Historic England

Arrangements for Handling Heritage Applications Direction 2021

**THE MANOR HOUSE, 5 EAST STREET, CROWLAND, SPALDING,
LINCOLNSHIRE, PE6 0EN
Application No. H02-0837-25**

Bedroom F9,
scale 1:100

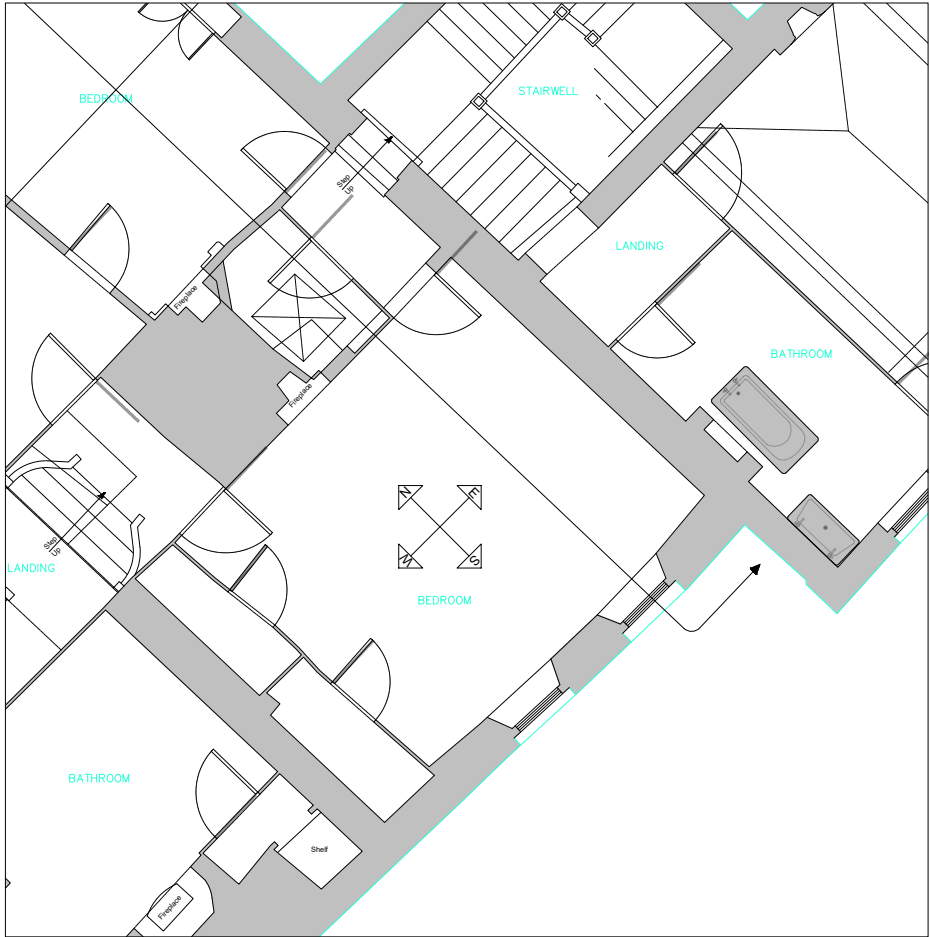
We also previously recommended that further information is provided to justify the extent of panelling proposed to be removed. We have seen additional information regarding this (omitted accidentally from H02-0837-25 amendment application) but provided to us separately. The additional information document (*Photographs - Additional Information* provided by Hutton + Rostron) consists of photographic evidence of the removal of panelling from the Great Room dating to 2001. We acknowledge that panelling has previously been altered and in light of this we refer to your Conservation Officer for further guidance on this matter going forward.
